An
Coimisiún
Pleanála

Memorandum:

Re: ABP Ref. No. ABP-310461-21

Development: Application for Substitute Consent for Quarry

MAINTENANCE & GARAGE DETAILS

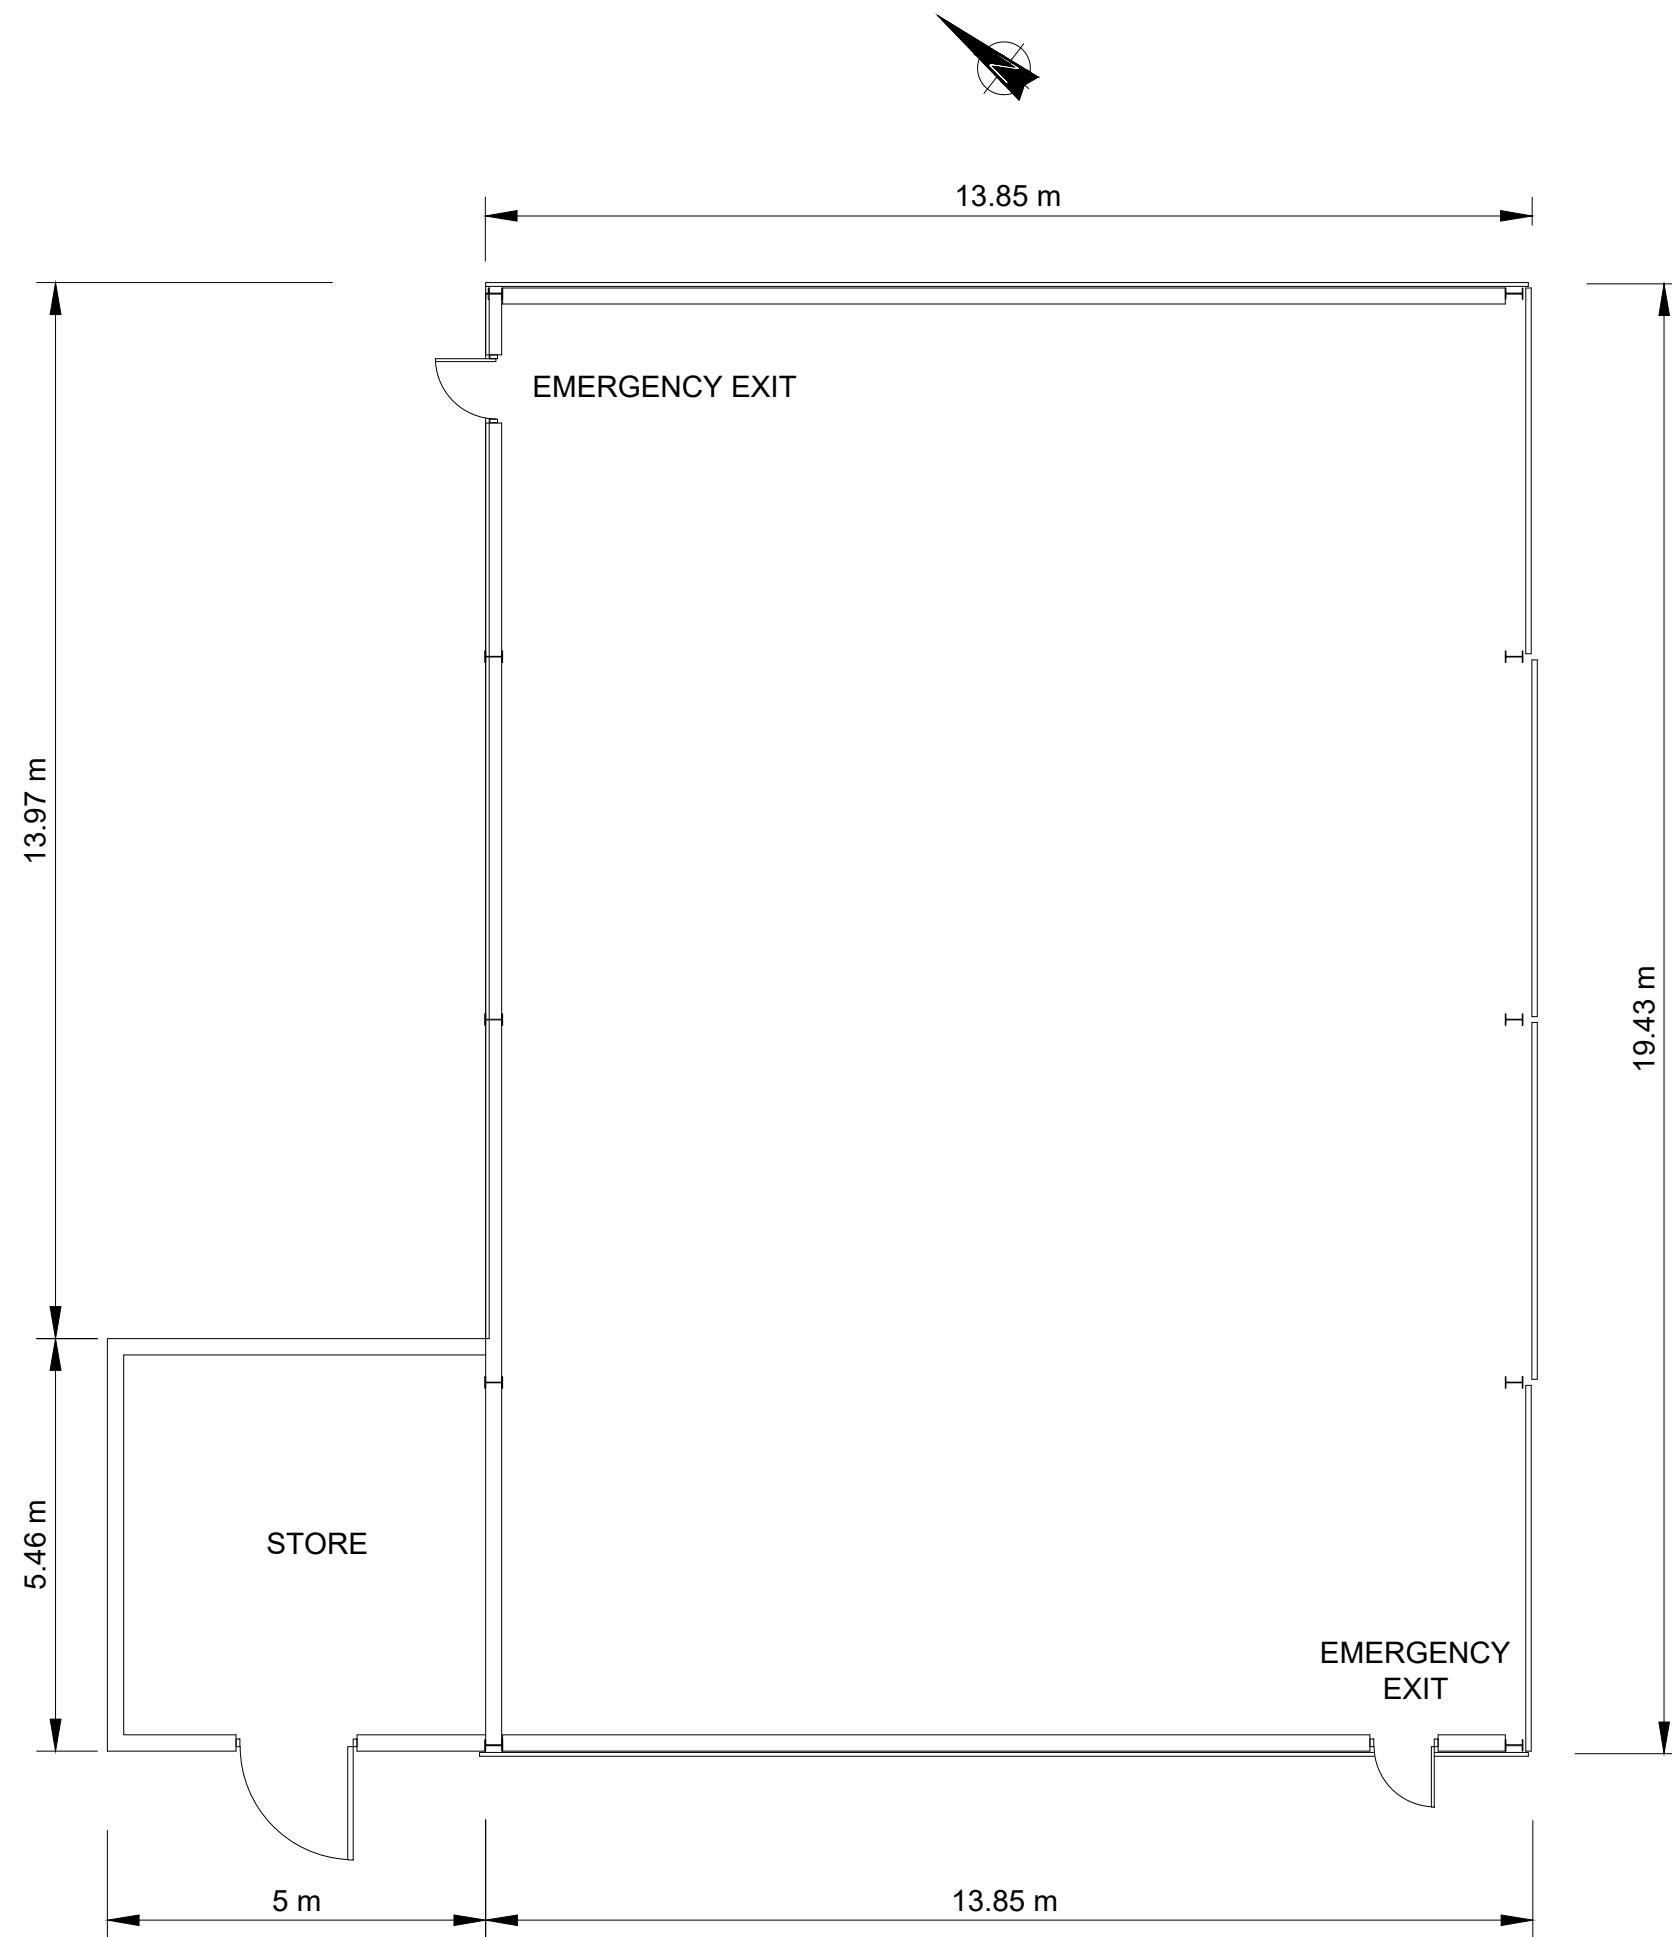
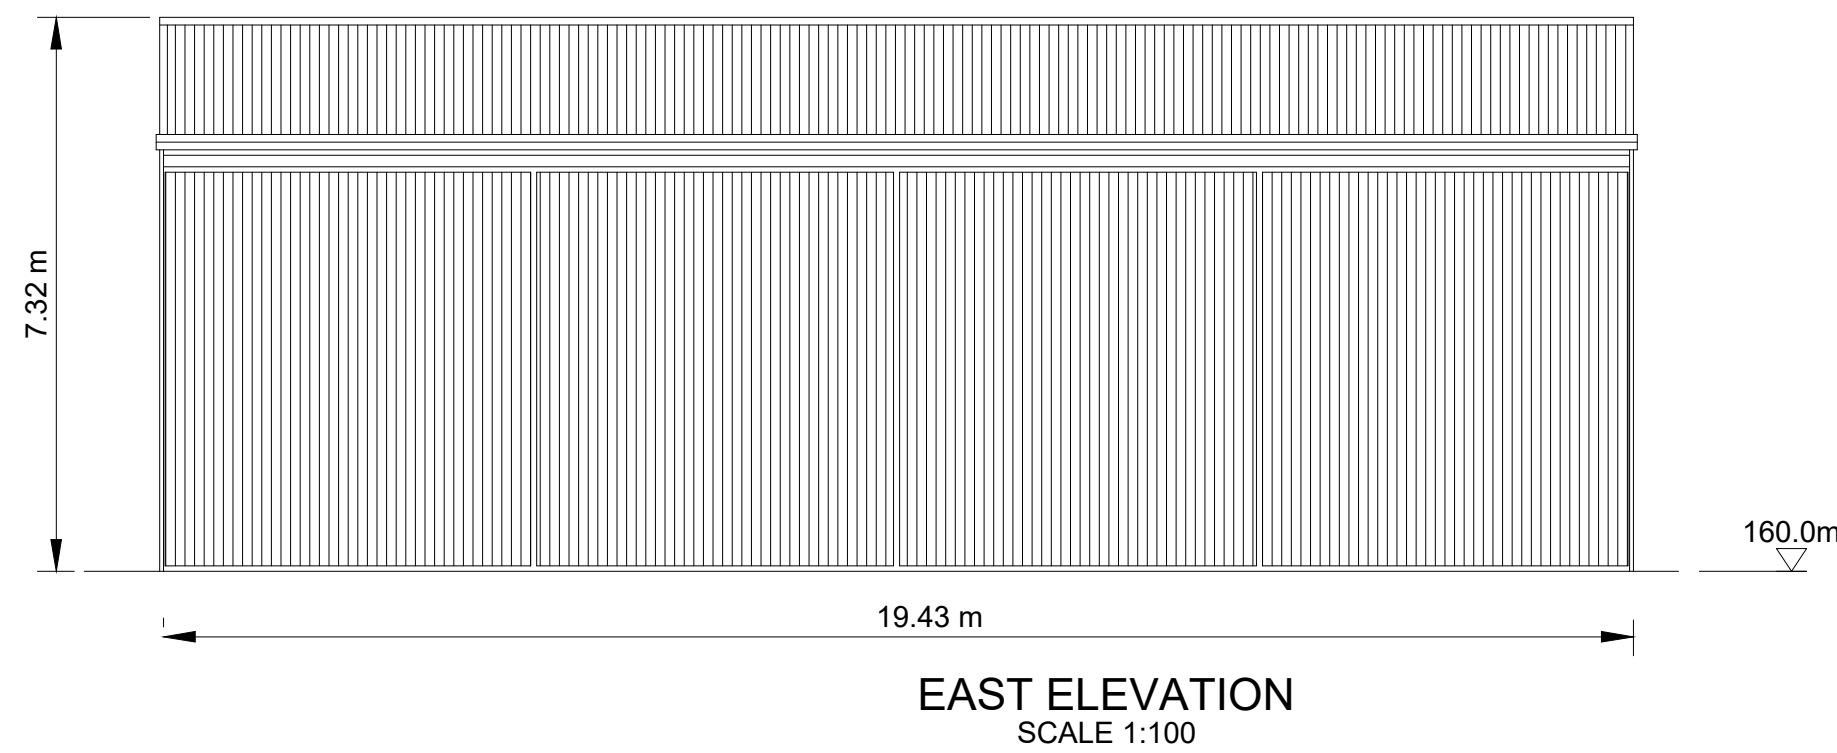
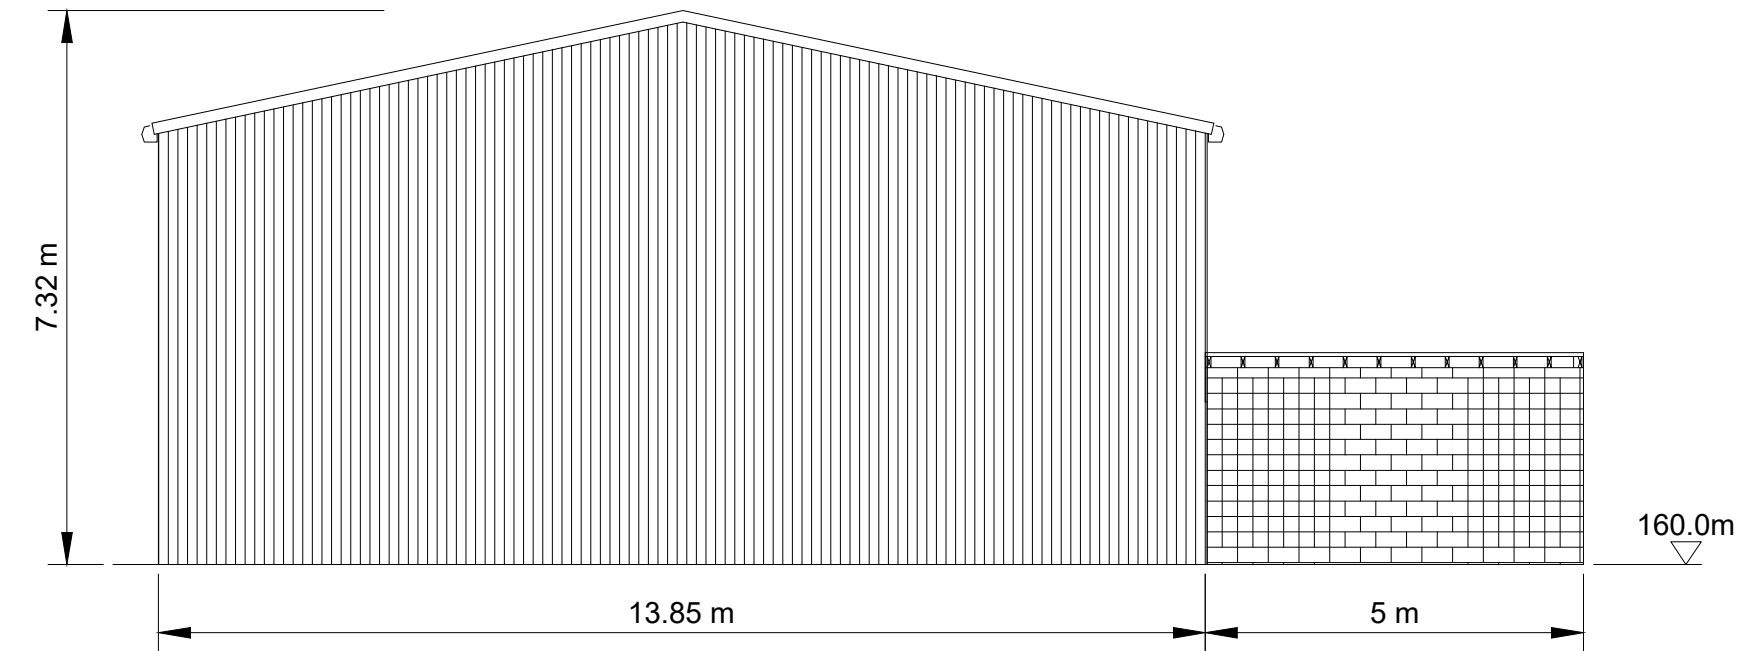
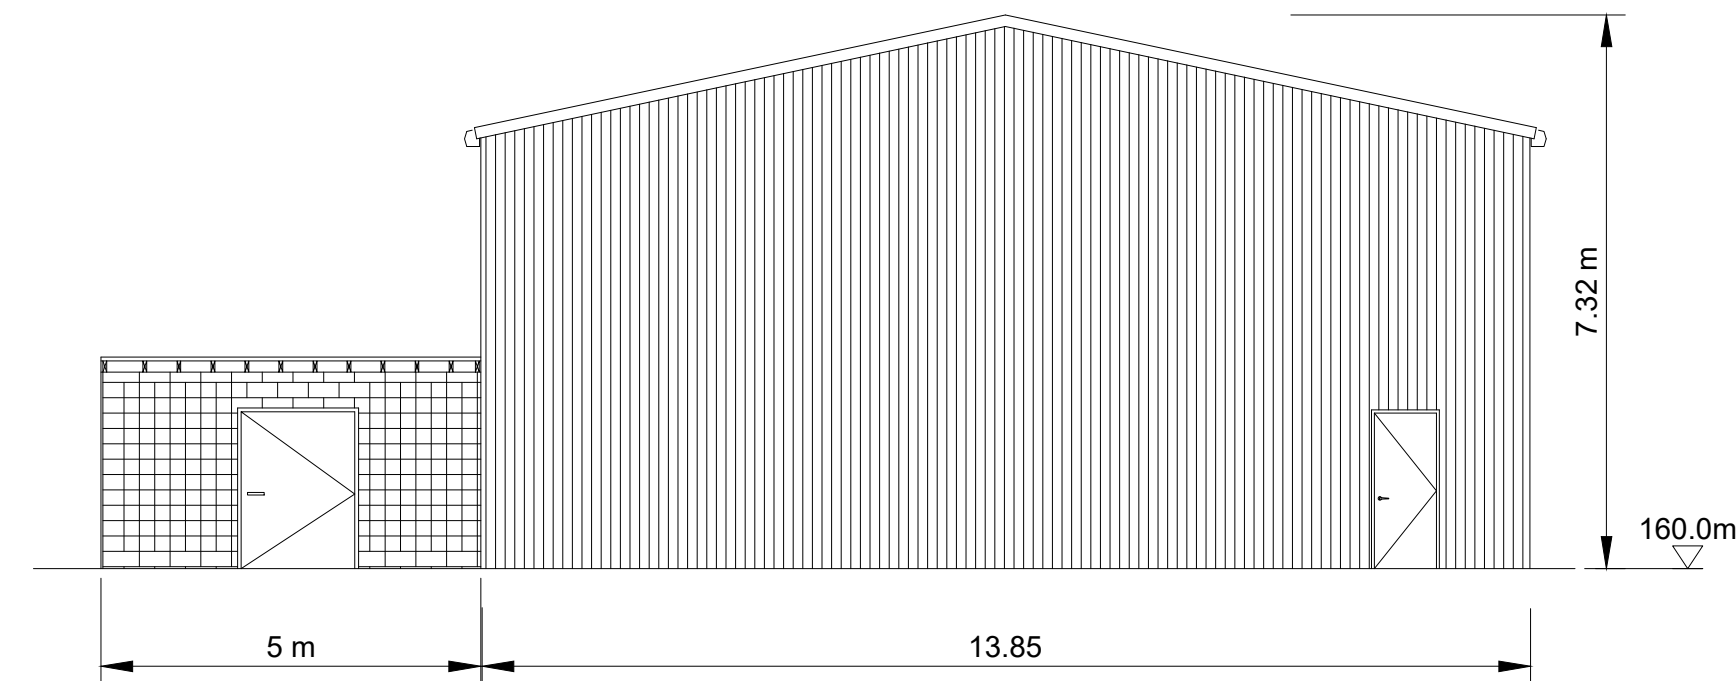
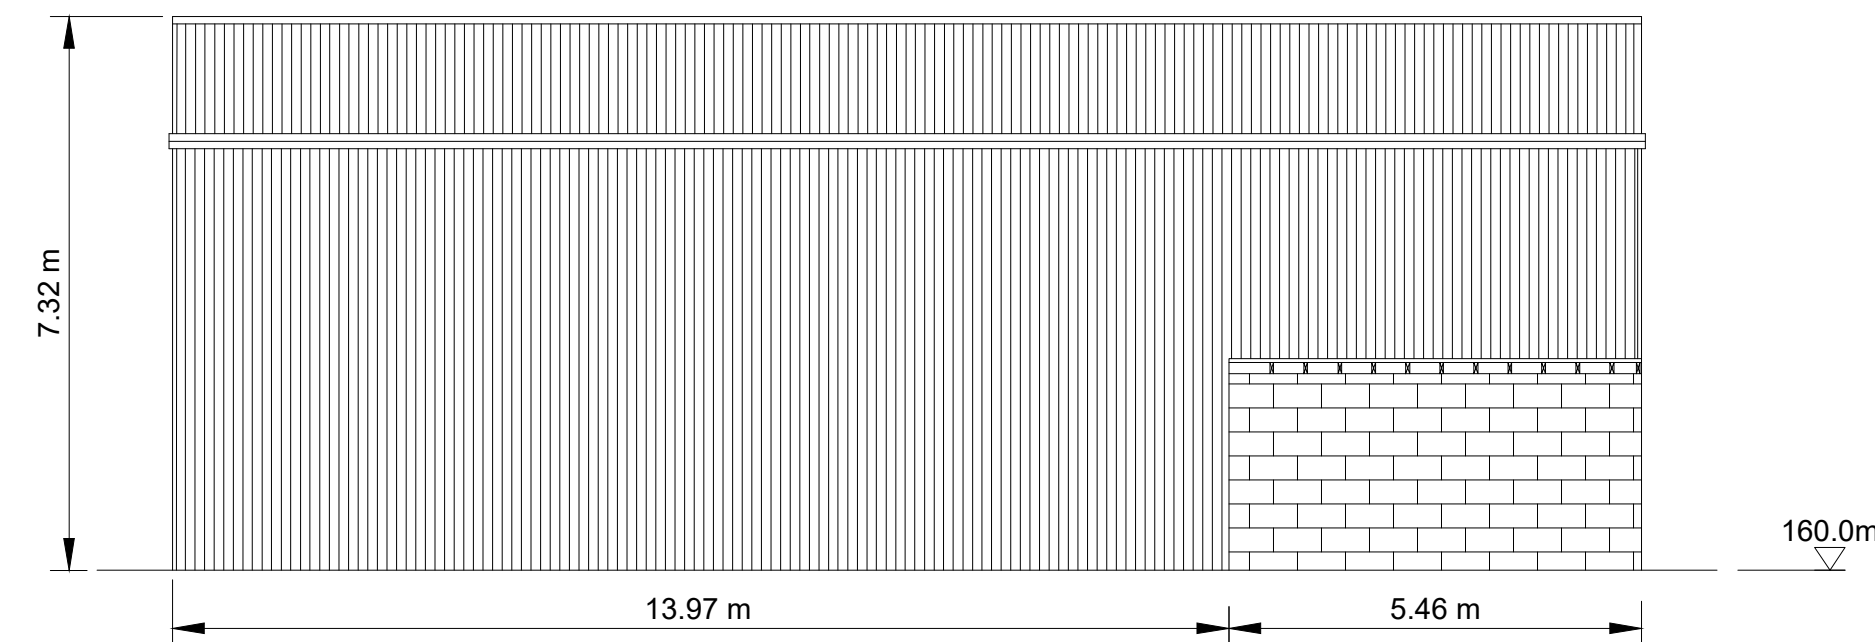
d) The 'Maintenance & Garage' Structure (Drg. No. 24):

Contrary to the plans and particulars submitted with the application for Substitute Consent (ABP Ref. No. ABP-310461-21), it has been confirmed from a site inspection that the existing structure situated within the administration & processing area and identified as a 'Maintenance & Garage' facility is not being used for any purpose associated with the current quarrying operation but is rather operating as part of the aforementioned car / motor sales operation (as evidenced by the vehicles present within the structure).

vehicles given that the 'Maintenance & Garage' structure detailed in Drg. No. 24 of ABP Ref. No. ABP-310461-21 is no longer being used for such purposes and instead operates as part of the previously mentioned car / motor sales operation.
